An Bord Pleanála,
64 Marlborough St.
Rotunda,
Dublin 1.

Date 23rd October 2022

RE : Dart + West+ Project . Reference 314232 . Interested Party not notified and excluded from process.

Drawn By: LA	Checked By: MH	Approved By: MH
Scale: 1:1250 (@A0)	Date: May 2022	
Area No: 038	Plan No: WORKS LAYOUT PLAN NO. WP038

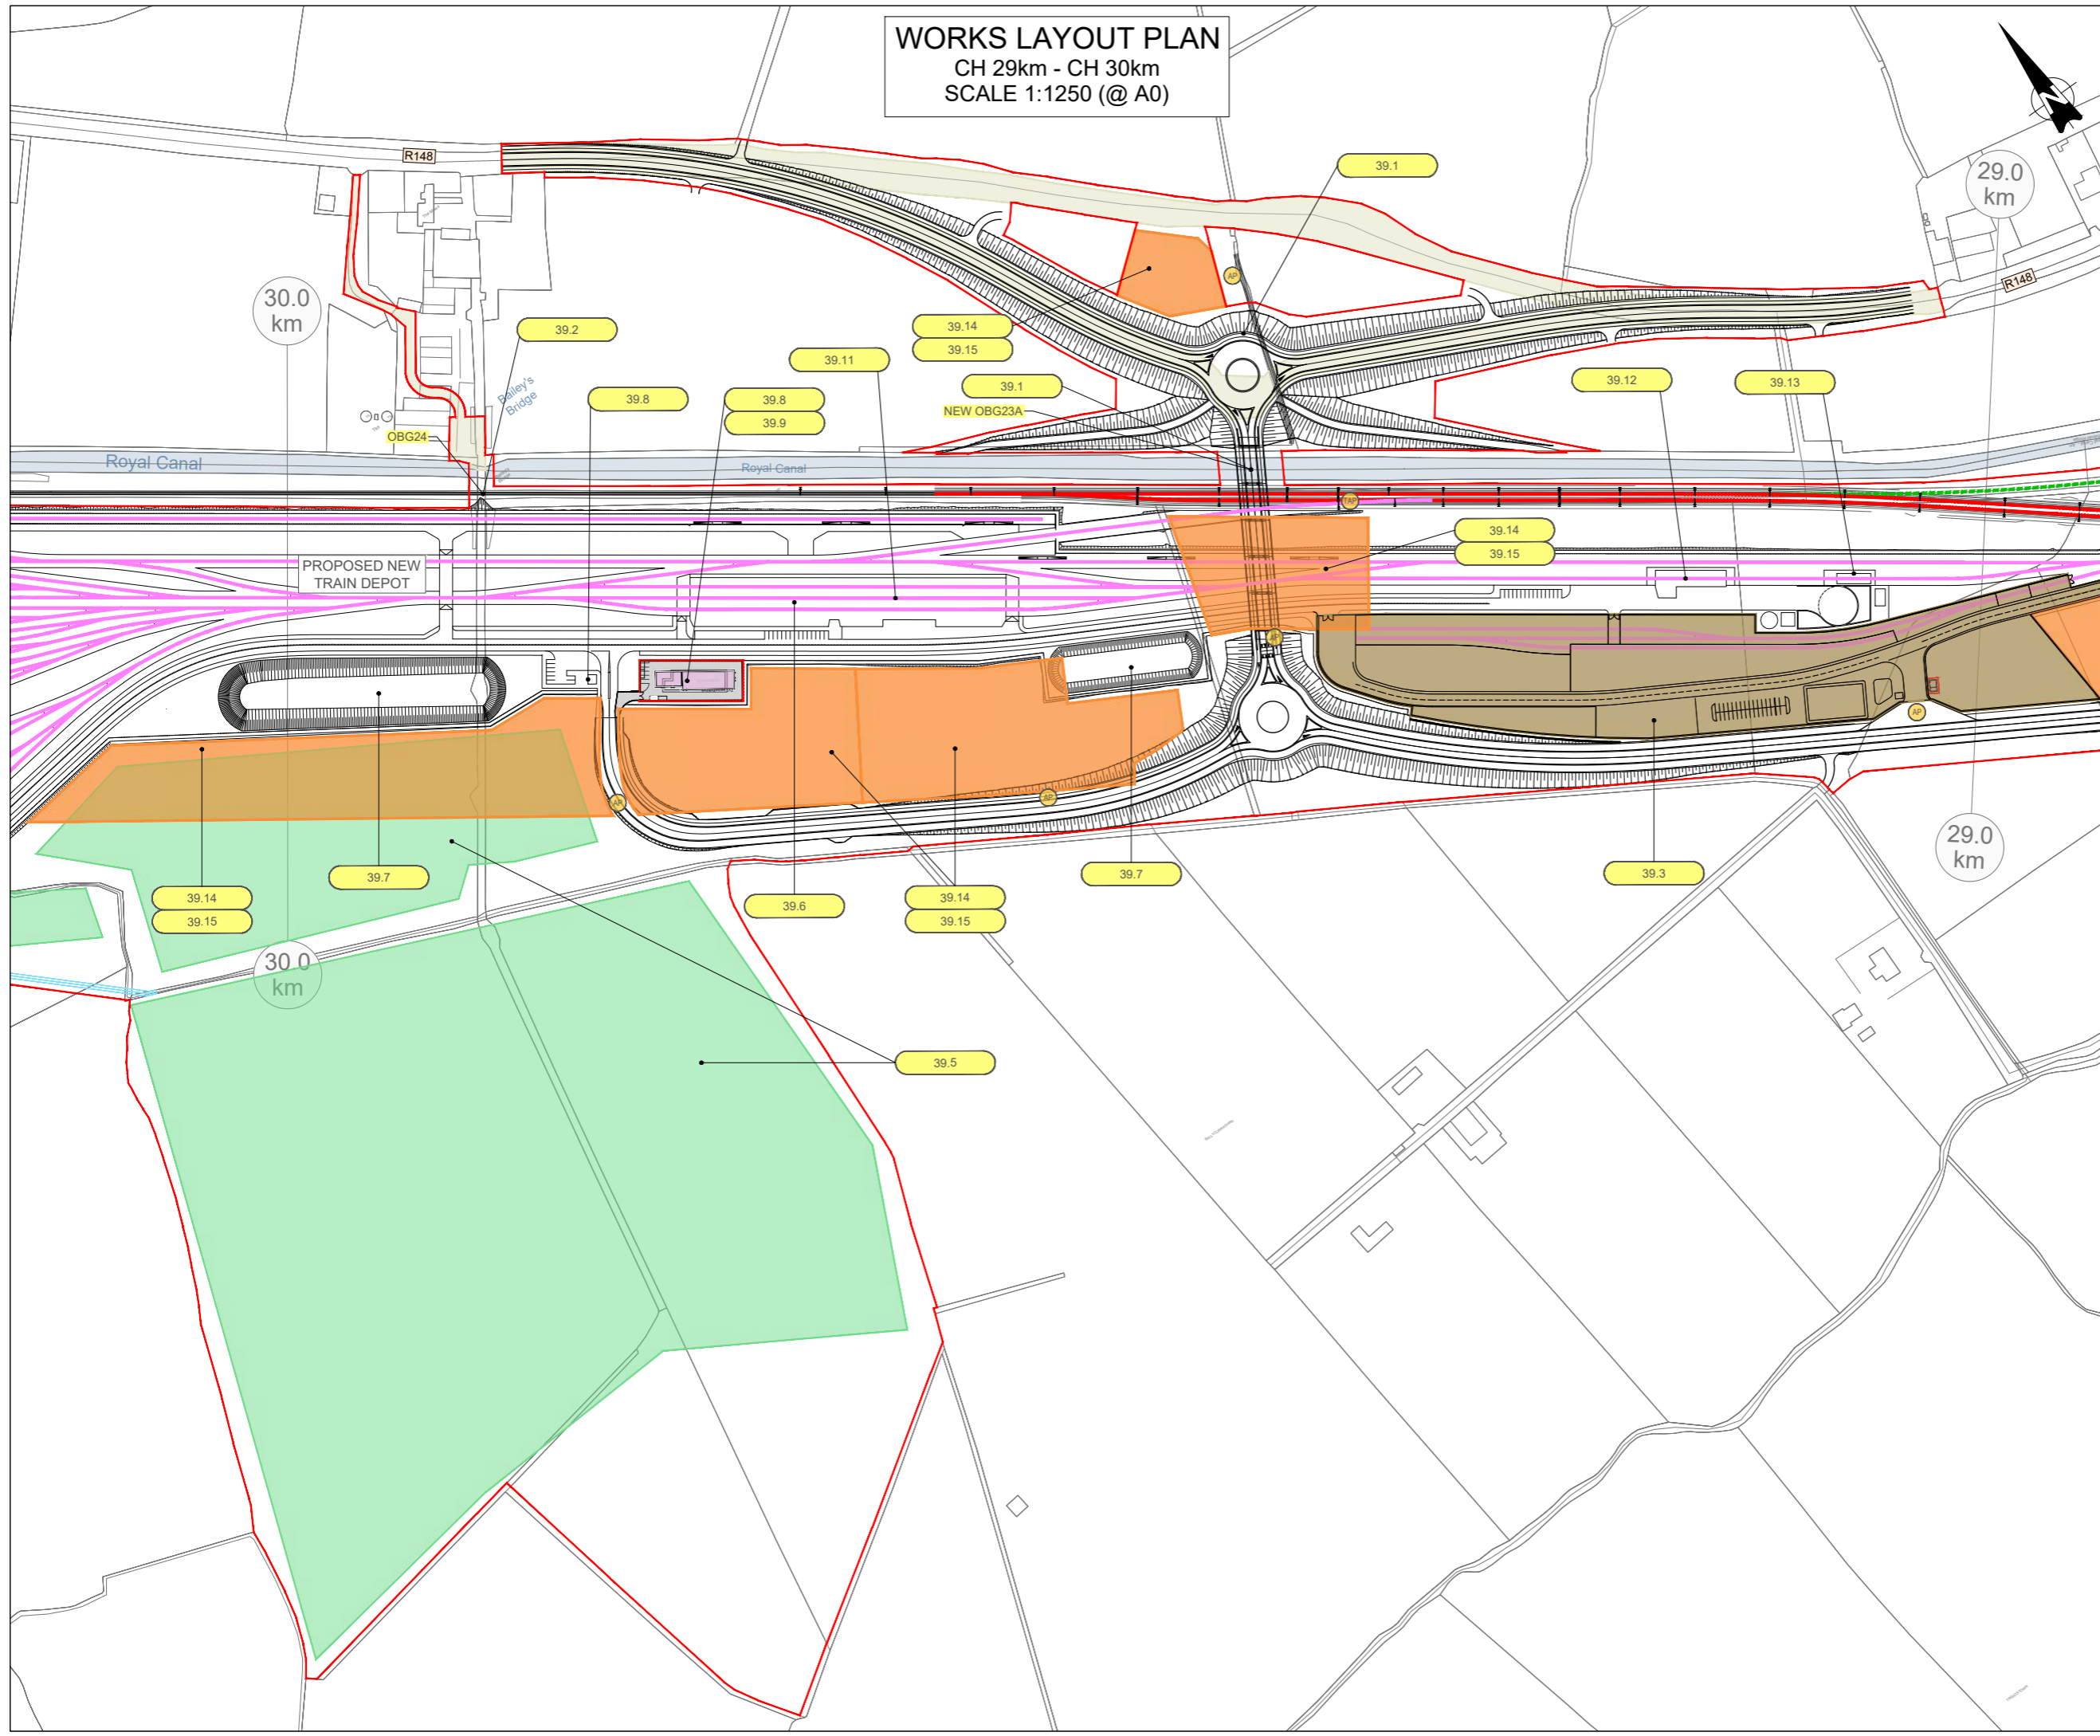
I referred to the railway orders book of reference schedules July 2022 4th schedule, *Lands of which temporary position may be taken*. According to the drawings submitted by Dart + West it is envisaged to carry out road alignment to private laneway reference DW0 38P 95b. Permission for this work has not been sought or has it been included the railway orders included with this application" dart West. I refer you to drawing Depot construction compounds Figure 5-387 below and Millfarm permanent way compound figure 5 -357 with areas of proposed works marked in yellow.

Drawn By: LA	Checked By: MH	Approved By: MH
Scale: 1:1250 (@A0)	Date: May 2022	
Area No: 039	Plan No: WORKS LAYOUT PLAN NO. WP039

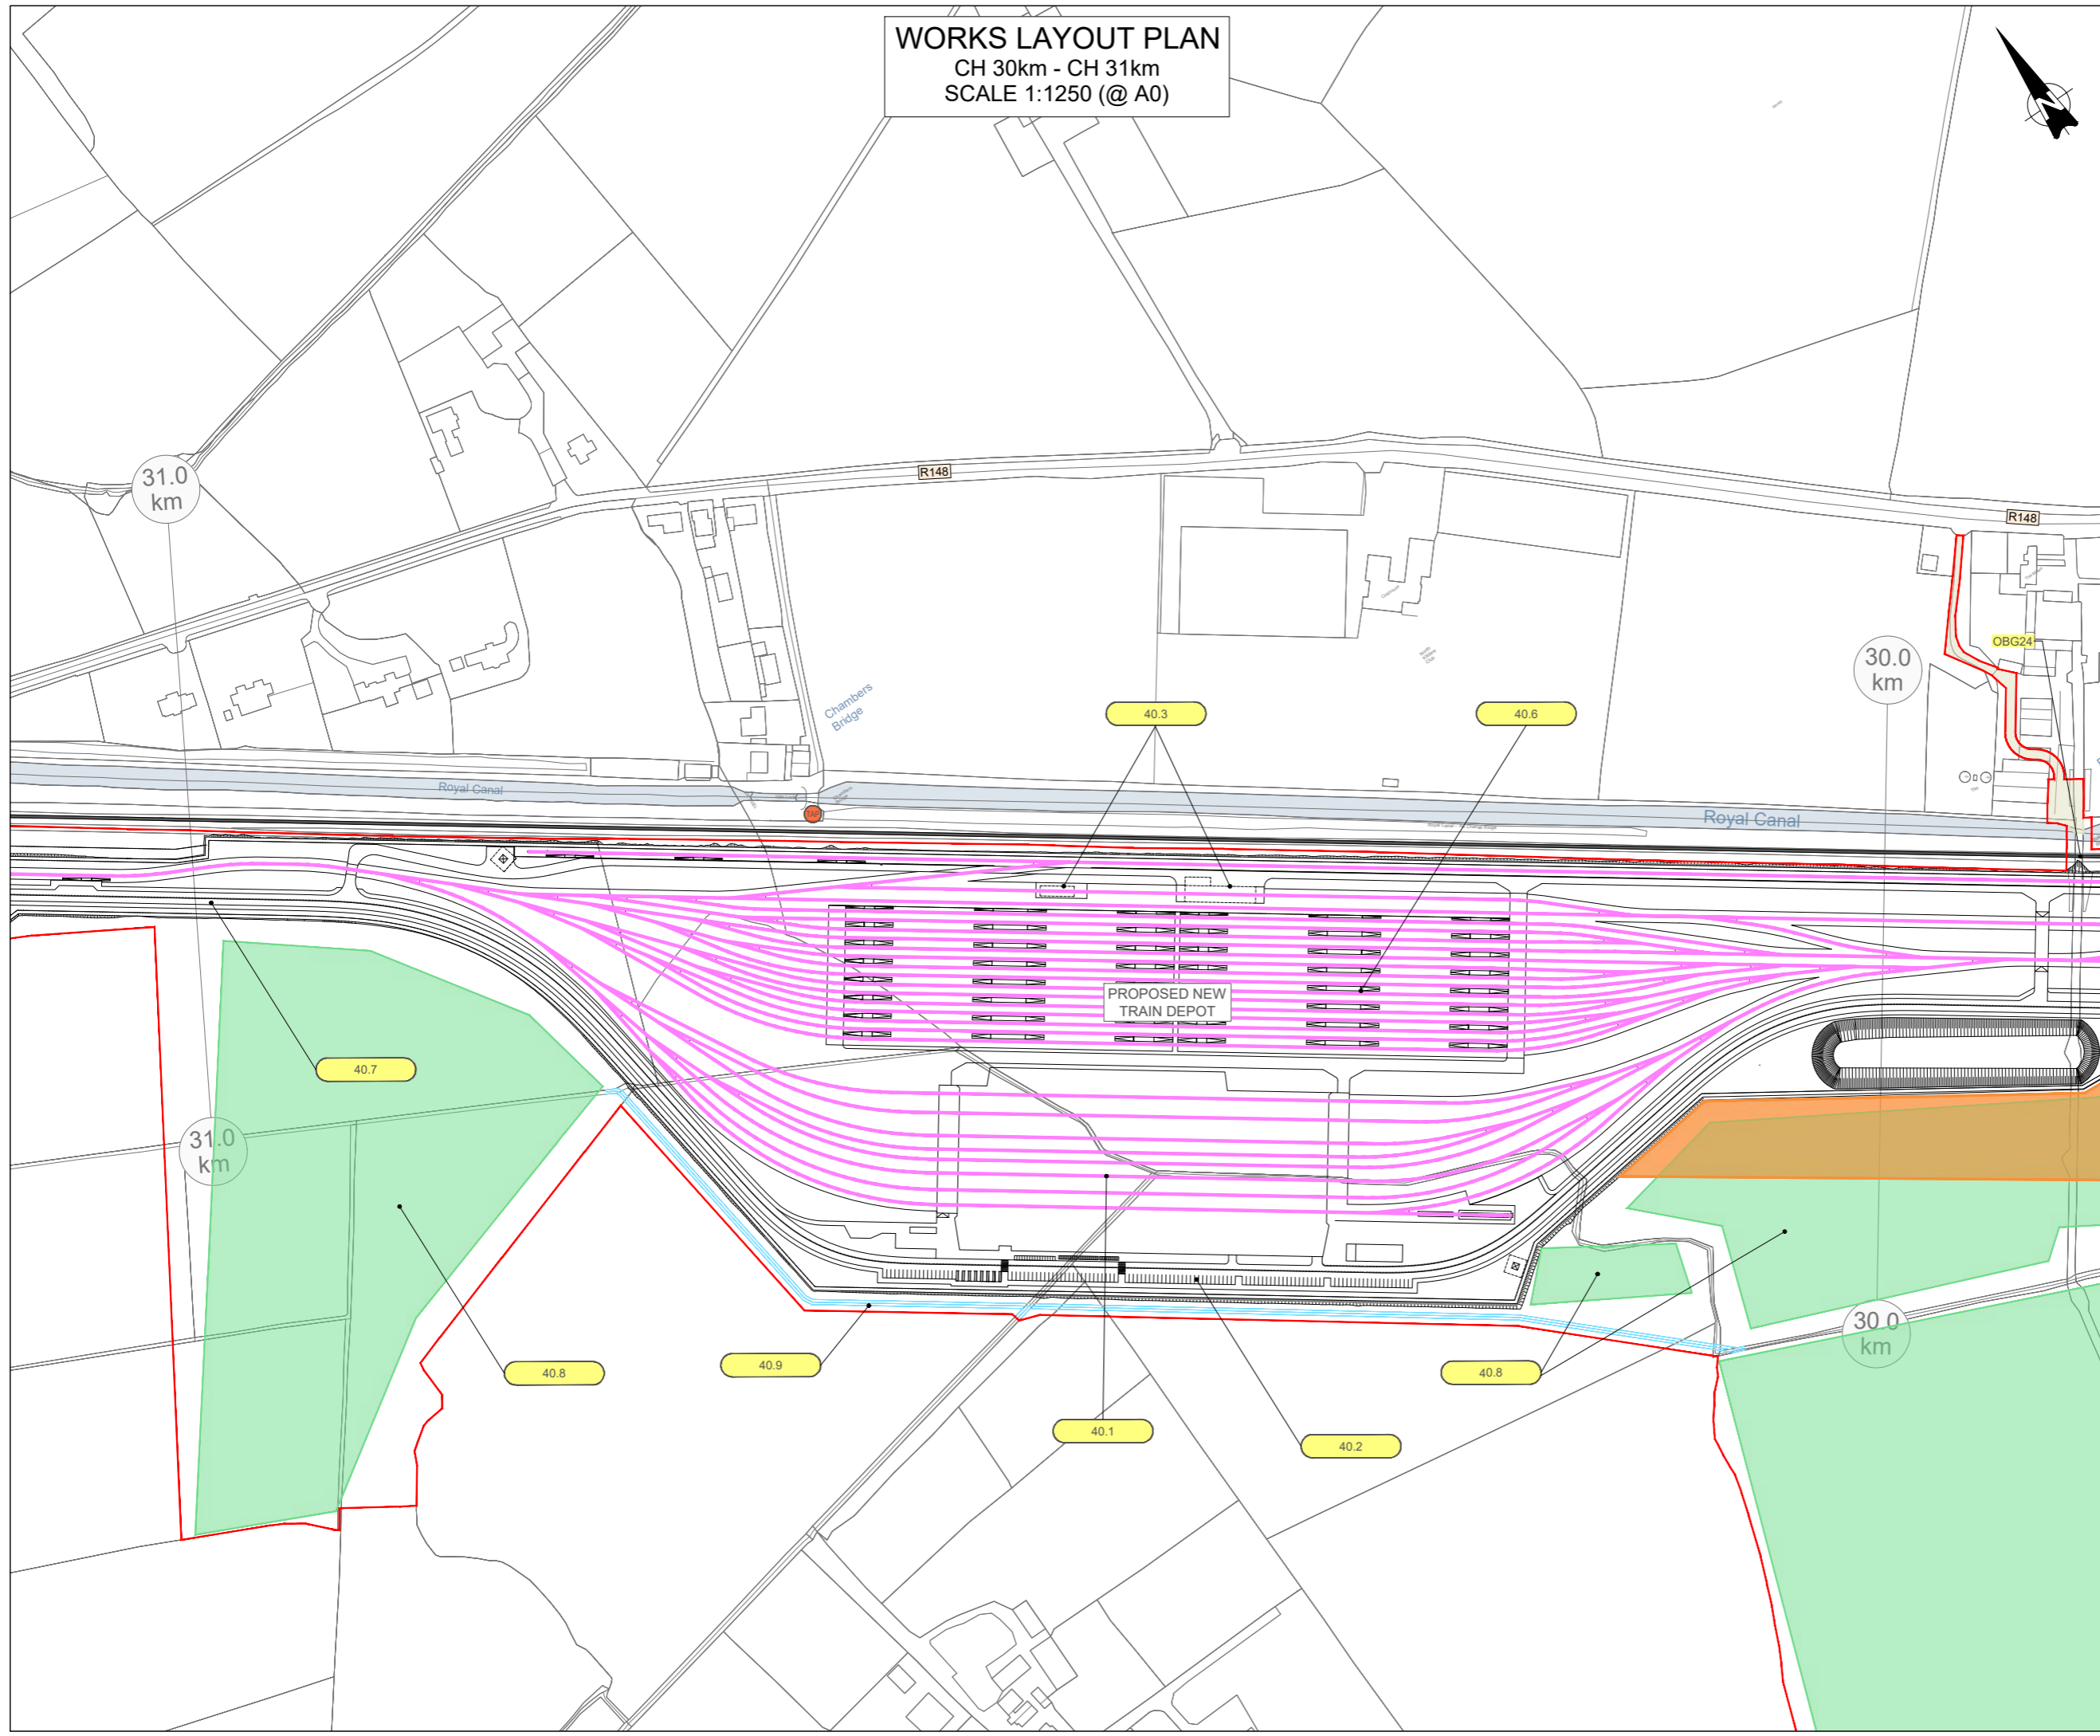
There is also the demolition of the existing bridge OBG24 and the construction of the new bridge OBG23A and a new link road access road from R.148 to the L5041. The road access to the Depot is located adjacent to the Northeast corner of my farm as shown on drawing "Works Layout Plan No WP39,

The diversion of the L5041 to the Northern boundary of Ballycurraghan and exposing the area to what will be a very busy public road will pose many problems for me including the problem of security of my property and farm. For many years we have lived 1 km at the end of a quiet private road. Dart + West now proposes to put a new entrance less than 150 meters from my house and farm. I will now have no option but

Another new entrance to new link road being provided between the L5041 and Ballycurraghan Lane one hundred and fifty meters from my property. Again, the residents of Ballycurraghan were not acknowledged in Railway orders and no consultation has taken place with residence of Ballycurraghan in this regard. In addition, there is no mention of Victorian stone arch over river at this point or why our right of way are being affected..
